DELEGATED HOUSEHOLDER DECISION

Item No. Report of the Interim Director of Planning, Regeneration & Public Realm**Address** 92 BERKELEY ROAD HILLINGDON**Development:** Single storey extension (following removal of side canopy structure).**LBH Ref Nos:** **60575/APP/2022/2562**

Drawing Nos: 92 / P / 2022 - 02
 92 / P / 2022 - 03
 92 / P / 2022 - 01
 92 / P / 2022 - 05
 92 / P / 2022 - 04

Proposed Side Extension

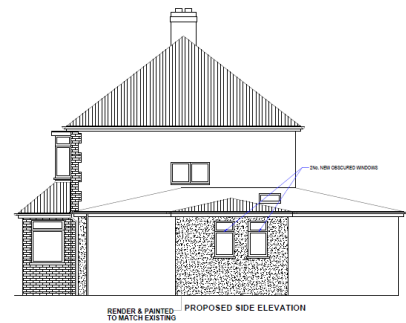
The cumulative width of approx. 5.6m to the original width of the host dwelling - approx. 5.6m would be far too dominating, imposing and disproportionate. Whilst the new addition would be set back into the site, the cumulative bulk would be excessive to the site especially given the entirely hardsurfaced nature of the site, prominent corner/angled junction alongside no.50 not being extended to the side. The solid addition would be very visible in both public and private views and fail to harmonise with the architectural composition of the host, failing to preserve the streetscene successfully. The lightweight canopy does not justify the footprint and envelope of the new addition as it reads as a lightweight addition to the property with a very different visual impact.

As per the elevations, especially given the angled nature of the site, the addition would appear incongruous, disjointed and visually intrusive to the dwelling and views from the streetscene.

Whilst only a 'partial' side extension, this central and 'part' nature would in fact make the massing appear odd and disjointed.

The proposed single storey side extension in conjunction with the current side extension, by reason of its prominent siting, cumulative and combined height, depth and width, design, bulk and massing would result in an awkward, incongruous, disproportionate, visually intrusive and excessively wide addition that would harm the architectural composition of the original dwelling, relationship with no.50 Lynhurst Crescent of which it forms part to, character and appearance of the area and visual amenities of this prominent streetscene. Therefore, the proposal would be contrary to Policy BE1 of the Hillingdon Local Plan: Part One - Strategic Policies (2012) and Policies DMHB 11, DMHB 12 and DMHD 1 of the Hillingdon Local Plan: Part Two - Development Management Policies (2020).
